File: SF18/26804  
Job ID: DOC18/217262  
Your Ref: SSD 8544

**RE: Heritage Division comments on exhibition of Glebe Island Aggregate Handling and Concrete Batching Facility (SSD 8544)**

**Dr Siobhan Lavelle OAM**  
Senior Team Leader Specialist Services  
Heritage Division, Office of Environment & Heritage  
**As Delegate of the Heritage Council of NSW**

Figure 15 Area of identified archaeological potential (shown in red) associated with the alignment of the first Glebe Island Bridge

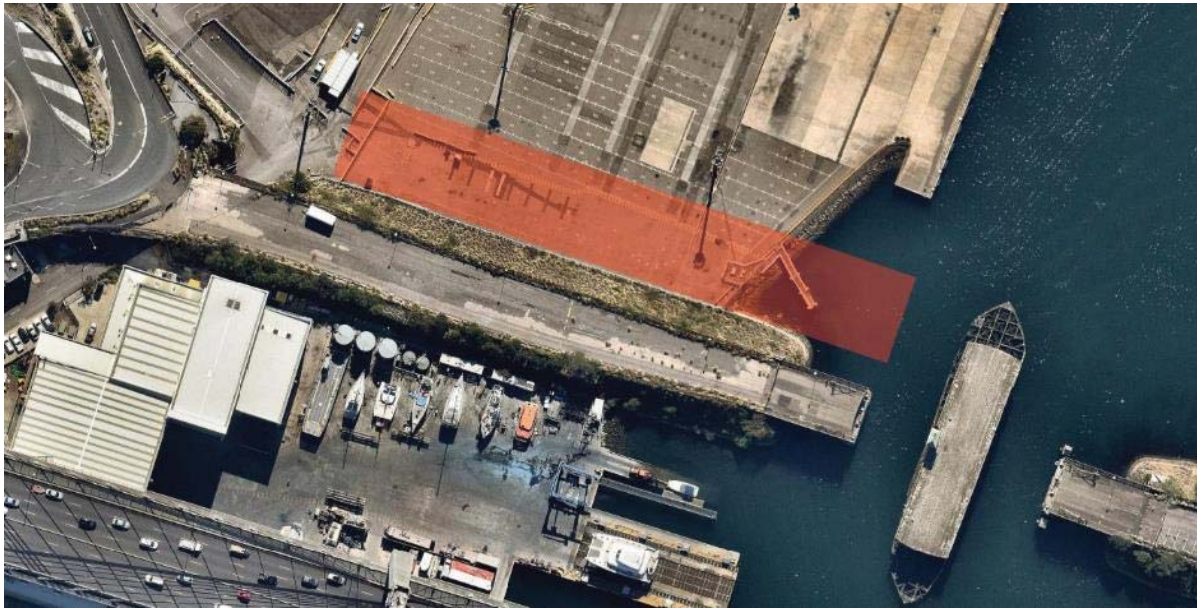
- The EIS included an assessment indicating the potential for archaeological resources to be present within the vicinity of the proposed silos associated with the concrete batching plant. The potential archaeological resources are associated with sections along the former alignment of Glebe Island Bridge across the harbour and the western abutments. The assessment indicated the proposed excavation below the current hardstand has potential to encounter the tops of former piles or relics not removed as part of the later reclamation works. Remains associated with the first bridge are likely to include former piles and other associated structural remains that may have been deposited onto the former foreshore or seabed area when it was removed from the site. The assessment indicated that these remains would have high research value to yield information relating to the construction techniques associated with the construction of the bridge.

- The assessment recommended the following mitigation measures, including, the preparation of an historical archaeological monitoring program concurrent to the excavation works including an Archaeological Research Design and Methodology for archaeological monitoring and a recording procedure of any remains or relics that are uncovered. However, it is noted that Archaeological Research Design and Methodology was not included as part of the EIS documentation.

- The EIS should address any impacts to potential maritime heritage sites including a search of the maritime heritage database.
- The EIS should be supplemented with an Archaeological Research Design and Methodology prepared by a suitably qualified and experienced historical archaeologist. The assessment should be prepared in accordance with Heritage Council of NSW guidelines including *Archaeological Assessments 1996* and *Assessing Significance for Historical Archaeological Sites and Relics 2009*.
- The detailed Archaeological Research Design and Methodology should be provided to the Heritage Council for review prior to any determination of the application. Based on this supplementary assessment to address these elements in sufficient detail, the Heritage Council would be able to provide more specific advice for recommended conditions of approval to manage this resource.
